Longridge Town Council

15 July 2011

Application No.	Location
3/2011/0475	E H Booth & Co Ltd, Berry Lane, Longridge, PR3 3NH

New link between existing Spar/Subway building and existing Booths sales building. Extension of existing Booths sales building to the west to provide support facilities to hot & cold food counters. Relining part of east car park to provide a safe loading area for goods vehicles, new disabled and parent & child car parking, and new parking in lieu of recycling point. Rendering of east Booths wall with access to car park.

PROPOSED SITE PLAN

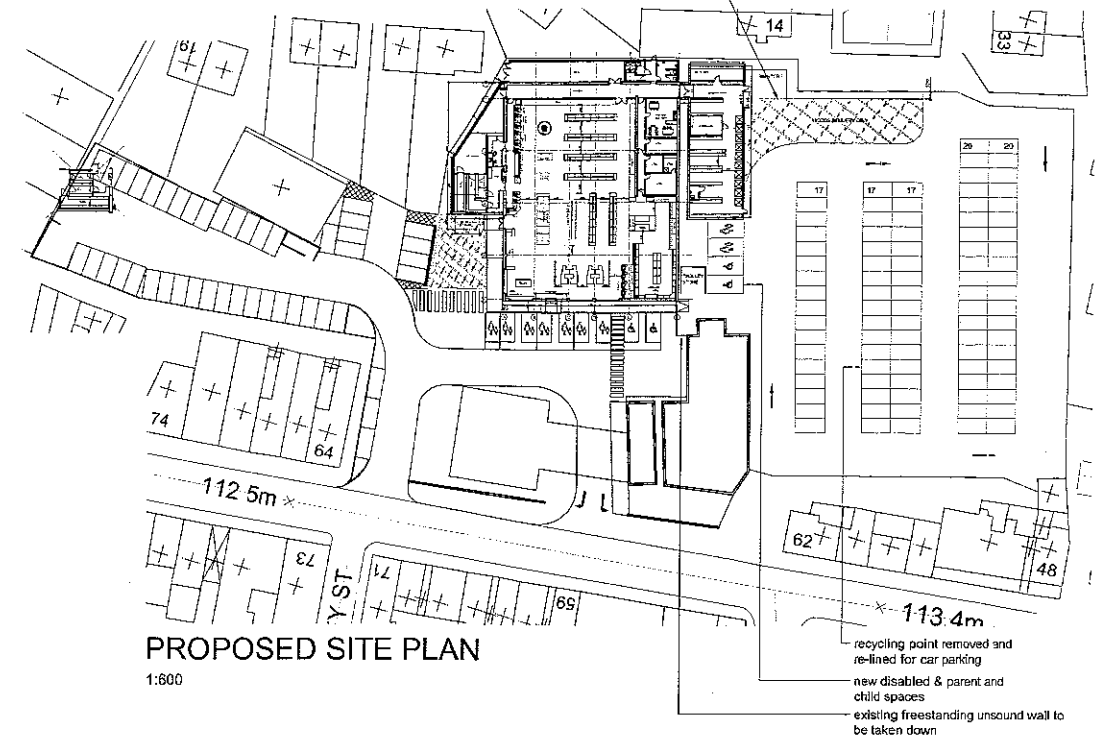
2. The Longridge Heritage Committee also draw attention to the external lighting around Booths premises which is left switched on throughout the night and is regarded as extremely bright. The Town Council supports the Heritage Committee concern and suggests that the proposed development provides an opportunity for a reduction in energy use and light pollution by reviewing the time the lights are used at night, and considering the use of lighting triggered by movement sensors.

3. Full consideration must be given to the potential for causing nuisance and disturbance to the neighbouring residential area. This includes sensitive location and sound insulation of machinery for heating, air conditioning and refrigeration etc. Loading times should be restricted to reasonable hours i.e. not during the night or early morning. Efforts should be made to reduce light pollution from the site. Any external staff smoking area should be located where noise and smoke will not interfere with any neighbour's enjoyment of their home.

PROPOSED EAST ELEVATION

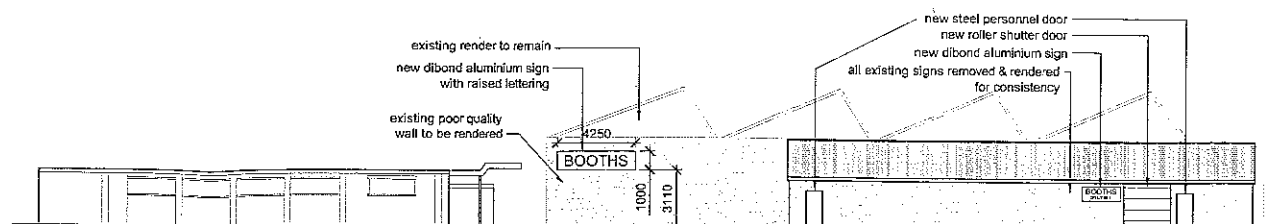
1. Councillors fully endorse the concerns of the Longridge Heritage Committee about the proposal to render 'East Booths wall'. This wall is the last remaining part of the Crumpax (Crampoaks) cotton mill of 1851, and if concealed would be a sad loss to the Town's heritage. The wall still features the stone and the alterations that have been made to it in the past. The Town Council supports the Heritage Committee suggestion that when the new access door is put in the wall it would be much more appropriate for the wall to be re-pointed so that this evidence remains visible. The wall features on the Longridge Town heritage trails and is regarded as an integral part of the history of the town.

SIGN 1 ELEVATION

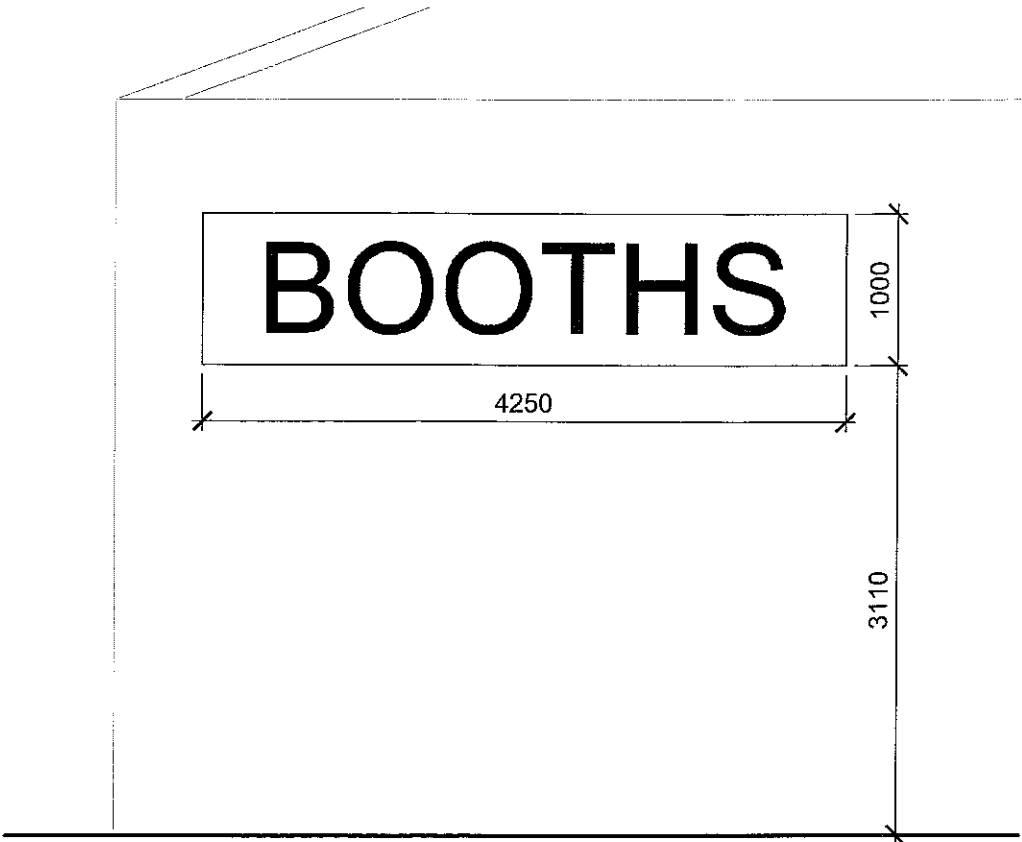
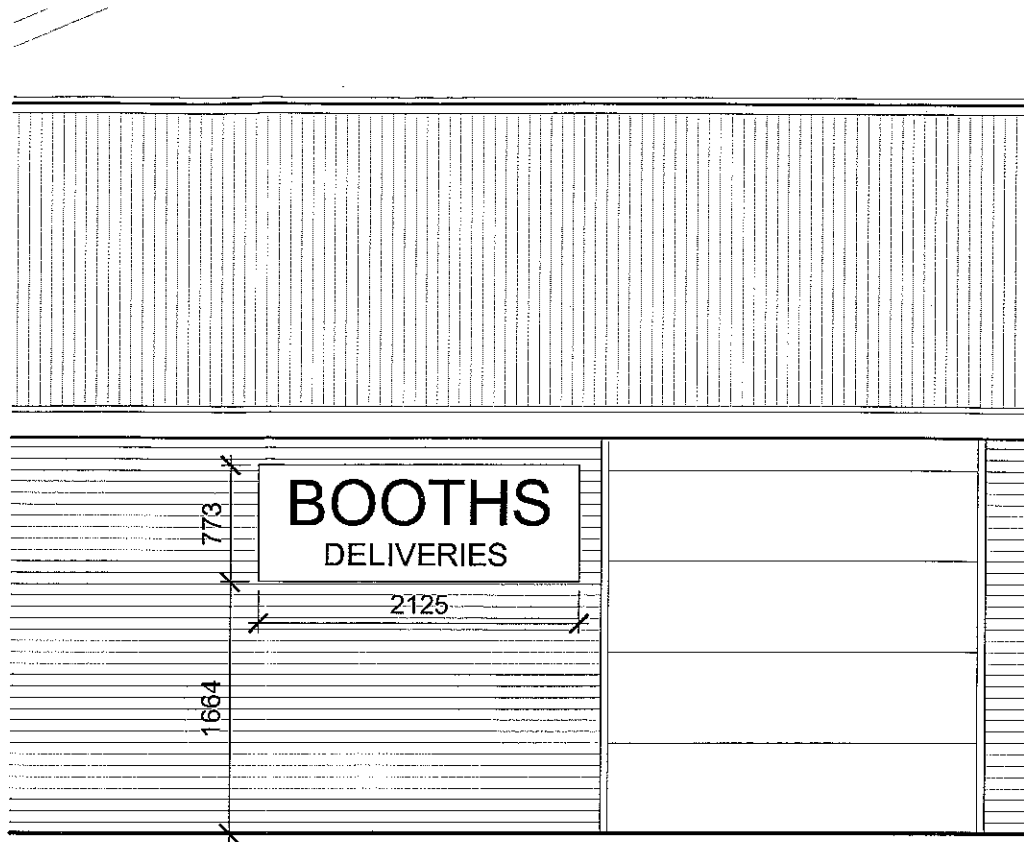
It was resolved that the Council has **no objection** to this application subject to the general comment at point 2 above (application no. 3/2011/0475) about light pollution. It is suggested that if approval is to be granted this should be conditional on the illuminated signs being switched off when the shop is closed to customers.
